EN010128 CORY DECARBONISATION PROJECT – NOTIFICATION OF INTENTION TO SUBMIT A CHANGE APPLICATION

I write to update you on matters pertinent to the preparation for the Examination of the Cory Decarbonisation Project ('the Proposed Scheme') and to notify you of the Applicant's intention to submit a Change Application in relation to a series of design refinements to the Proposed Scheme.

DRAWING TITLE:
**CARBON CAPTURE FACILITY
INDICATIVE ELEVATIONS
REGULATION 5(2)(o)
APPLICATION DOCUMENT
REFERENCE 2.10**

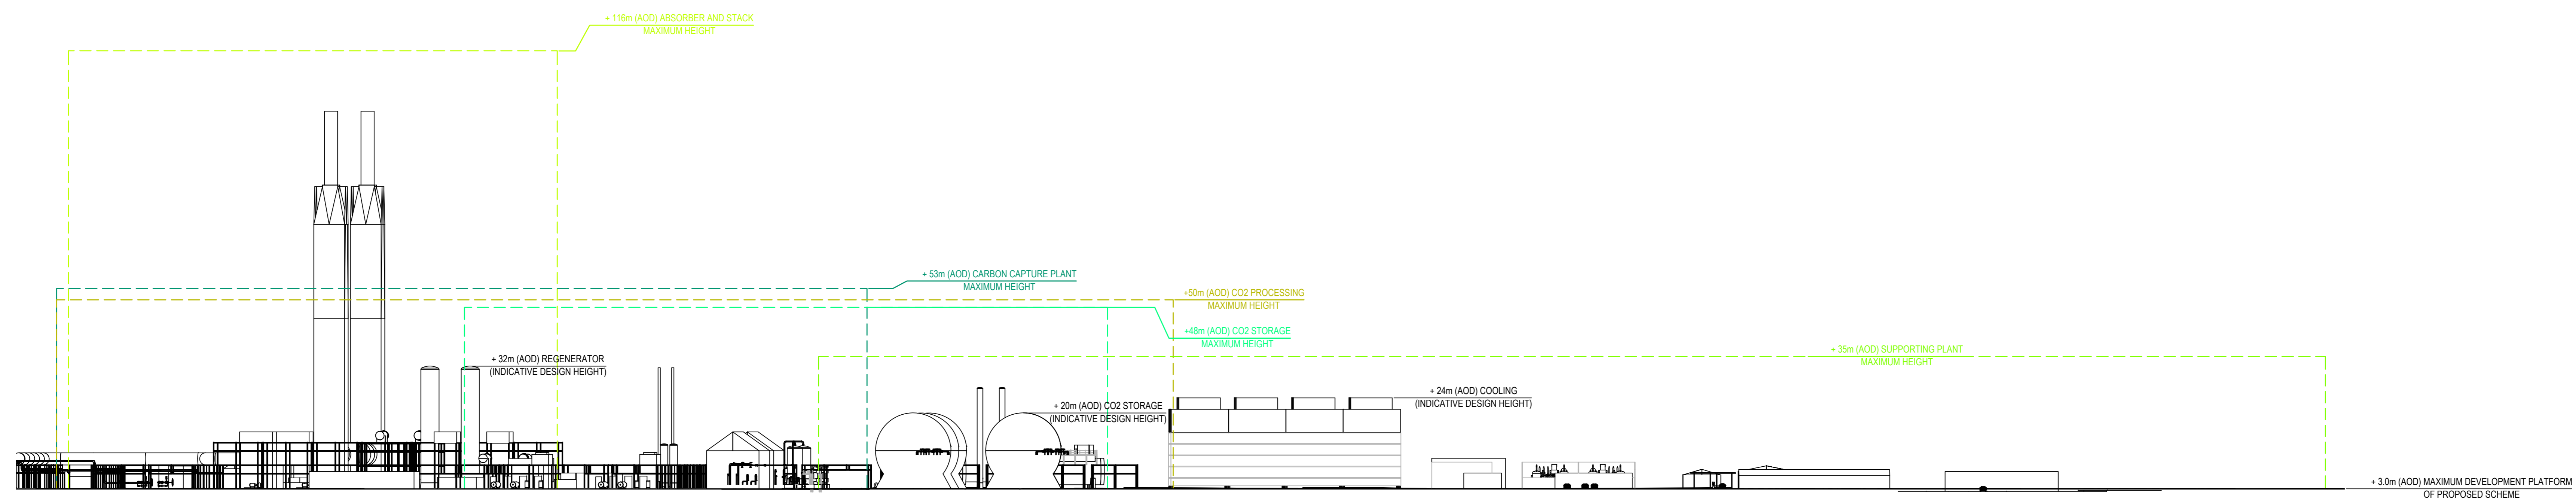
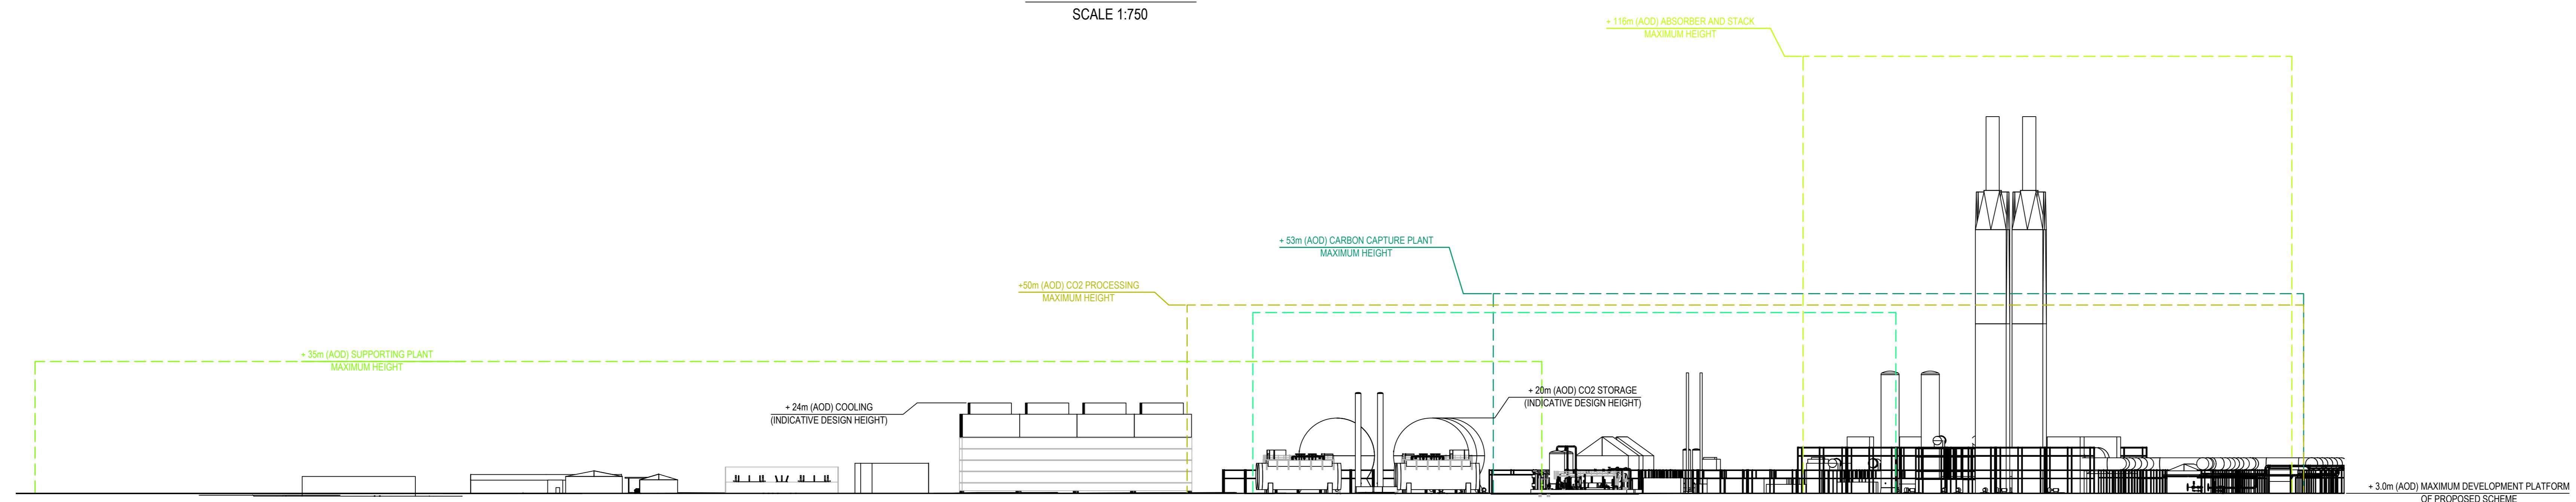
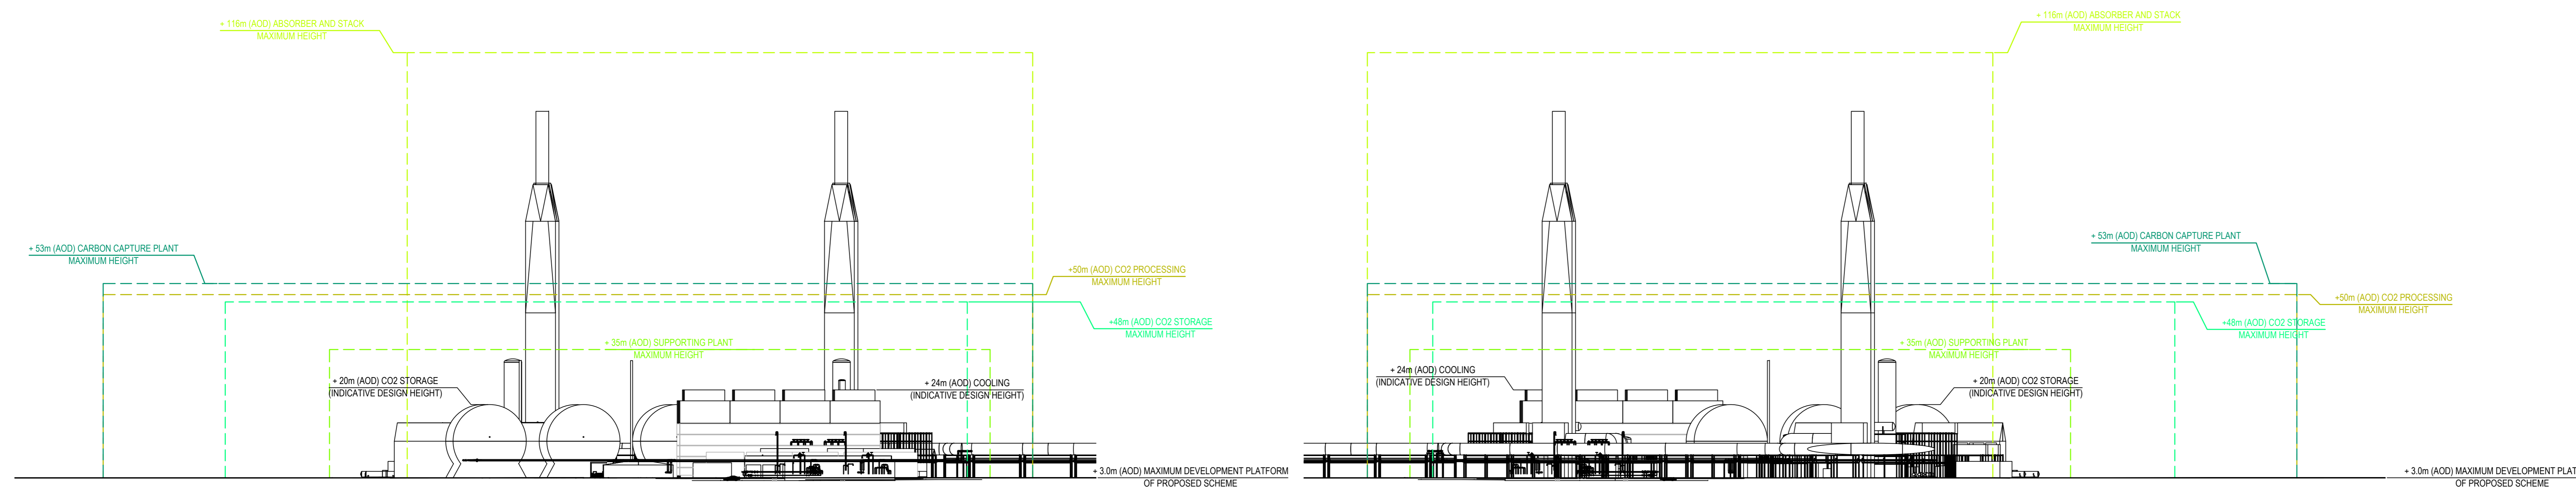
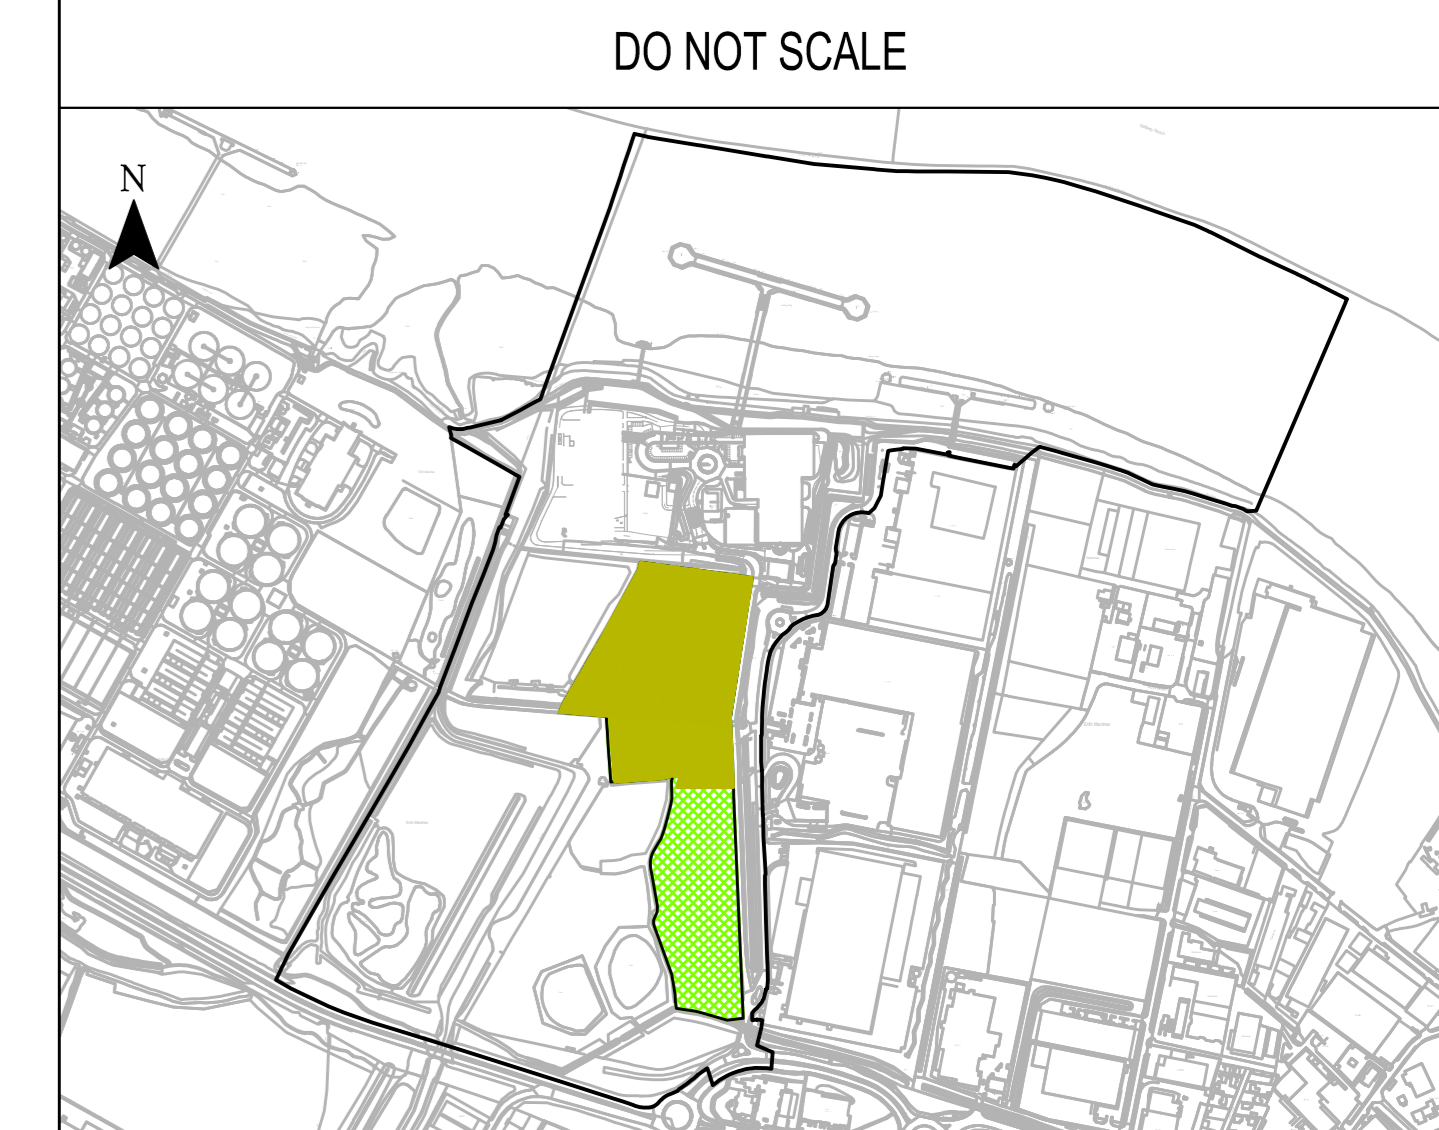
- Work Number 1B – The Stack(s) may no longer be located directly on top of the Absorber Column(s), rather the Stack(s) could potentially be connected to, but forming a separate stack, or totally separate from, and directly adjacent to, the Absorber Column(s). This change would facilitate a ground-mounted gas-gas heat exchanger, which may enhance heat recovery and reduce the cooling load for the Carbon Capture Facility. The height of the Stack(s) will remain similar to the current proposals. The Applicant will retain the minimum 30m distance between the top of the Stack(s) and the Absorber Column(s) to avoid downwash of pollutants. However, it is acknowledged that greater clarity of this potential design approach needs to be accounted for in how the parameters are expressed in Schedule 16 of the DCO, and so this will form the basis of the Change Application.

- Potential maximum increase in the height of the 'Regenerator' – The Applicant now seeks the flexibility for the Solvent Regeneration System to be able to be constructed, such that the Regenerator Column sits above the Solvent Processing System, rather than separately, thereby increasing the overall height of the System to 60m (63m AOD)¹.
